HIDDEN CREEK ESTATES

A PORTION OF THE SOUTHEAST ¼ OF SECTION 33, TOWNSHIP 11 SOUTH, RANGE 67 WEST OF THE 6th PRINCIPAL MERIDIAN, COUNTY OF EL PASO, STATE OF COLORADO.

SE 1/4 SECTION 33
FINAL PLAT

File Number: SF253

HAY CREEK ACCESS STA 1+00.00 TO 7+65.00

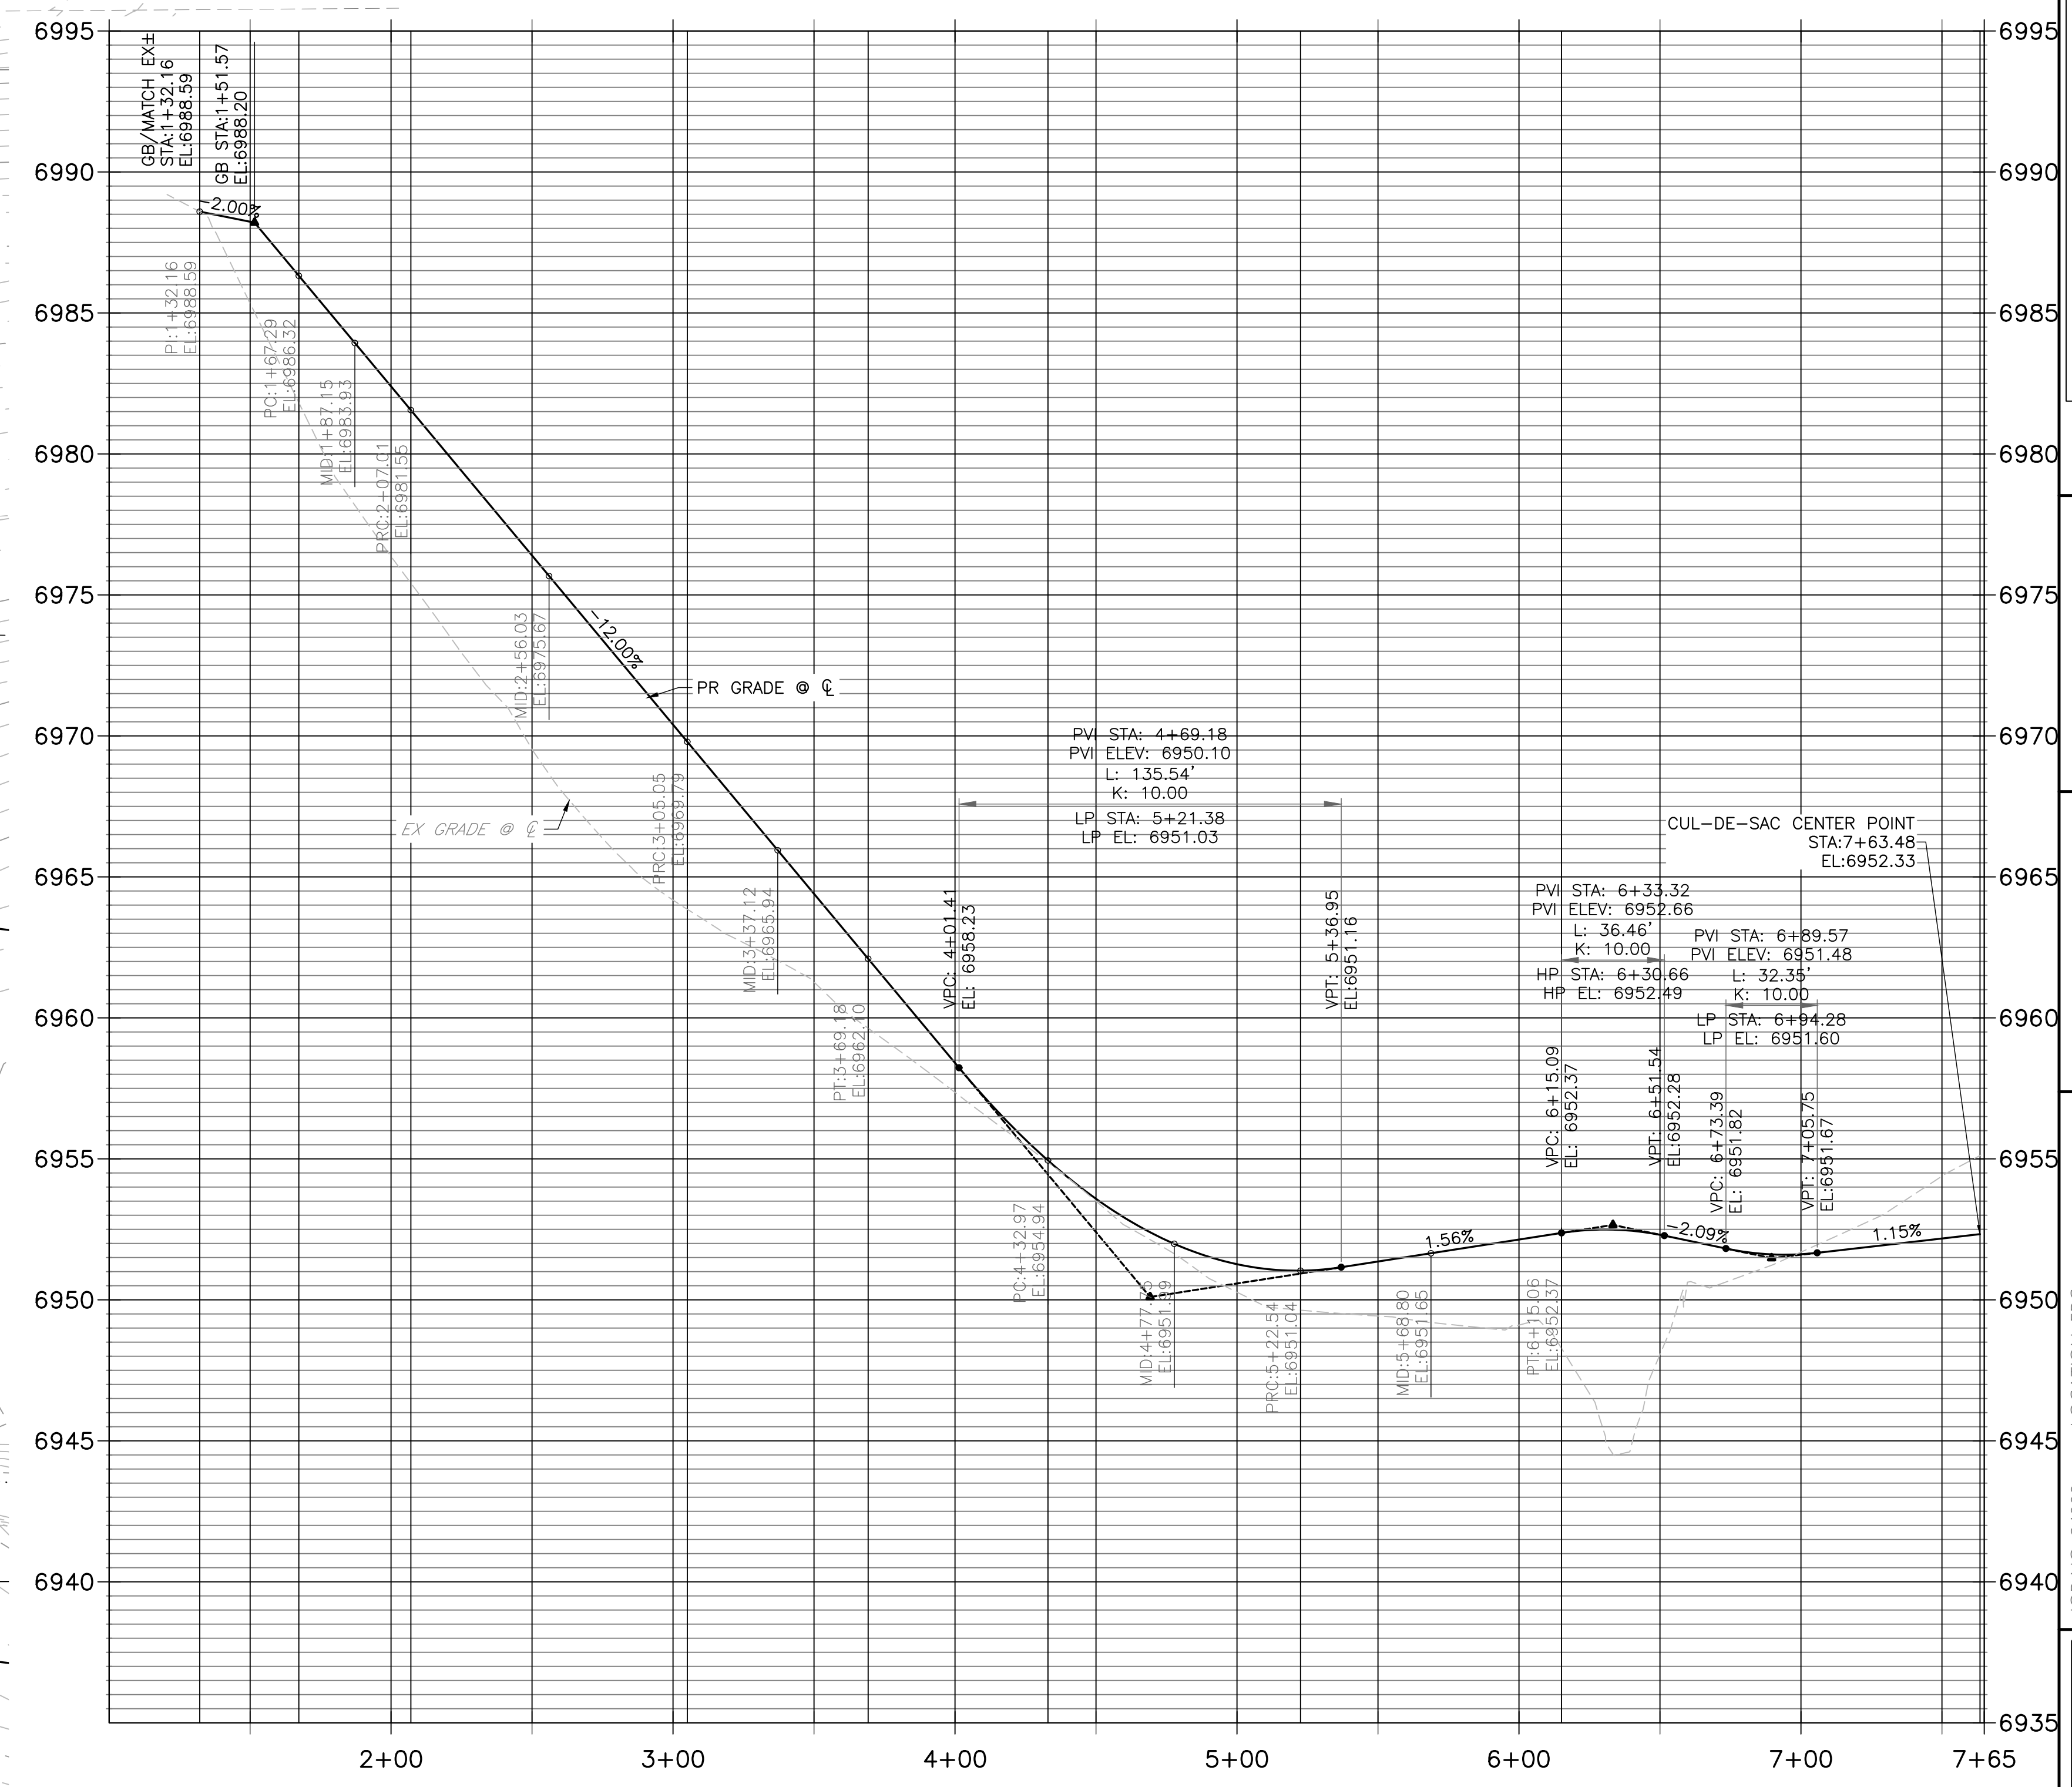
Provide the grade of the access road.

Please review the construction drawings for the roadway details.

Per section 6.3.3.C.3.j.ii The turnaround at the terminus shall have a minimum radius of 50 feet.

Provide feet of the proposed radius

RESPONSE: Per meeting 5/6/25 the Fire Department can make the determination on what is acceptable. Johnathan Bradley has determined the access to be acceptable.

RESPONSE: radii added. The Fire Department has approved the proposed private roadway.
